Final Drainage Report

Palmer Solar Facility El Paso County, Colorado

AASI-18-006

Add this to the cover of the final drainage report for the AASI-18-006.
The Palmer Solar facility Final drainage report will be reviewed for acceptance during the Site Development Stage of this Project.

**MAP NUMBER  
08041C0970 F**

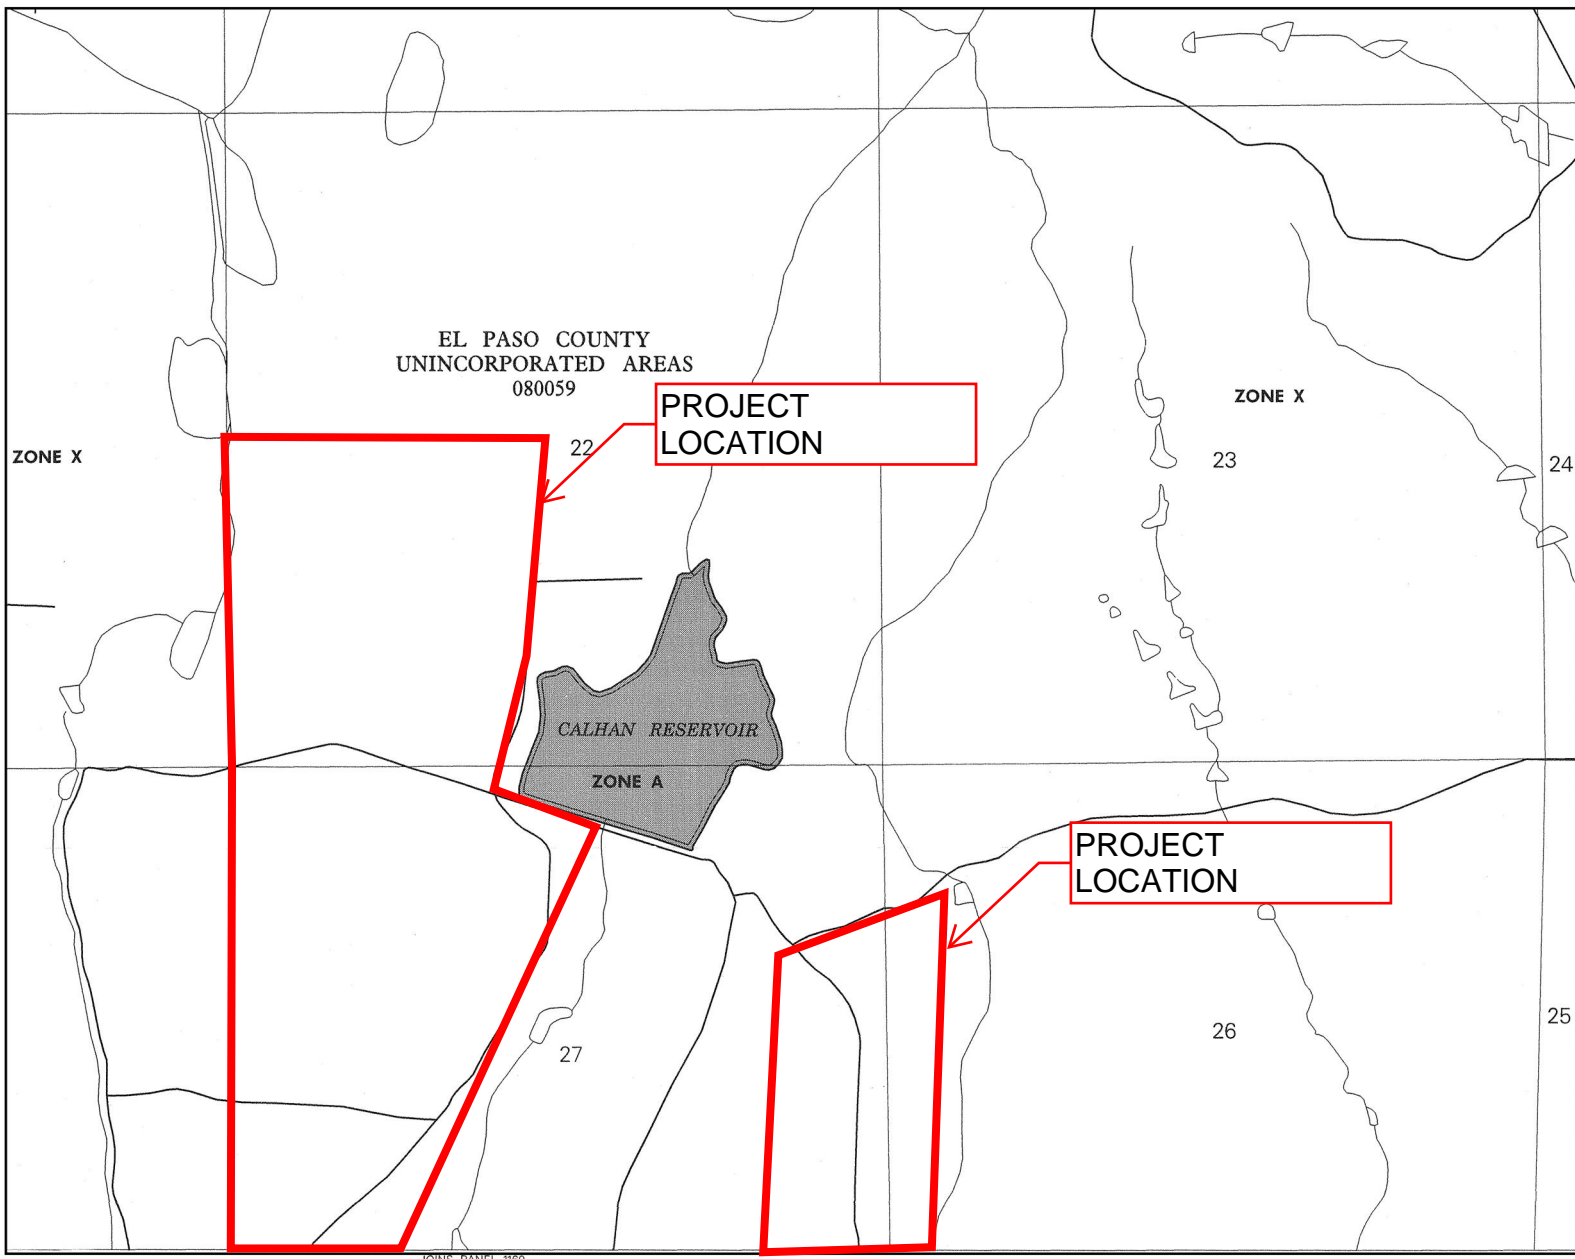
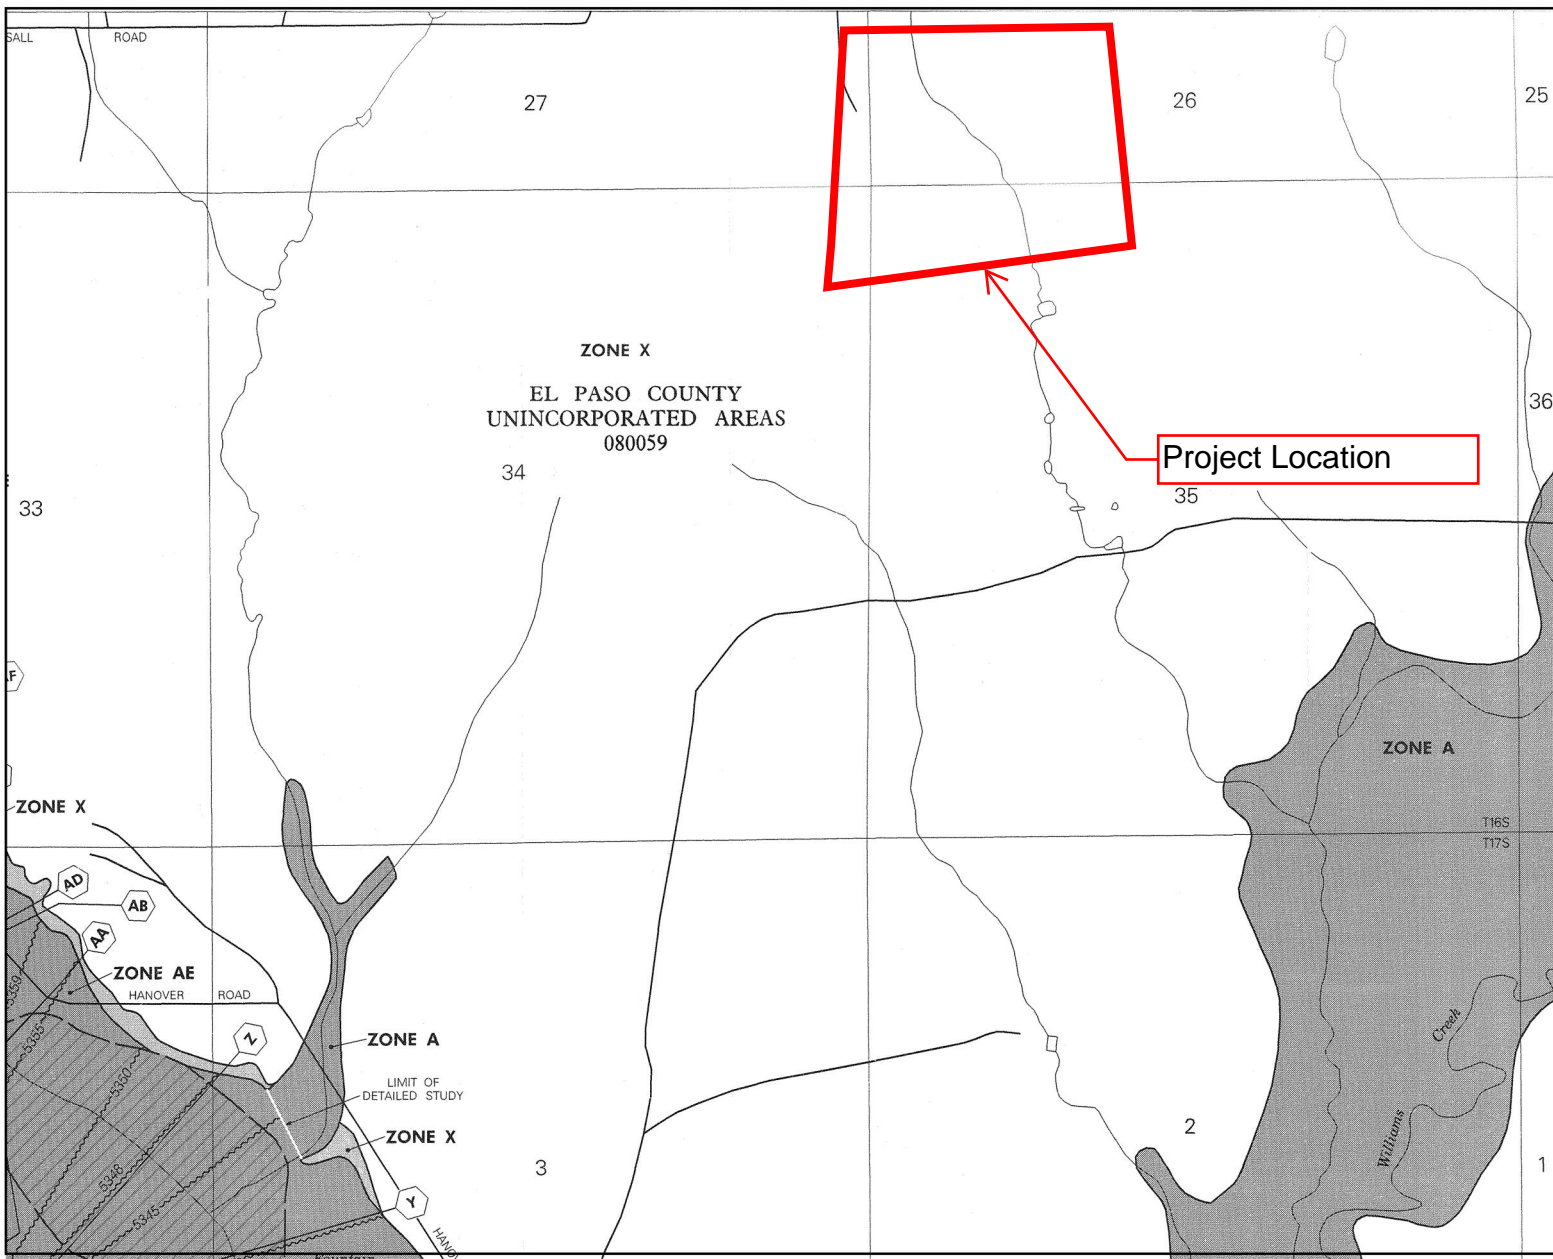
No portion of the Project is located within the 100-year floodplain as determined by the Flood Insurance Rate Map (FIRM) numbers 08041C0970F and 08041C1160F effective date, March 17, 1997 (see Appendix). **Provide the updated FIRM maps. Effective Date**

Provide the updated FIRM maps. Effective Date
 December 7, 2018.
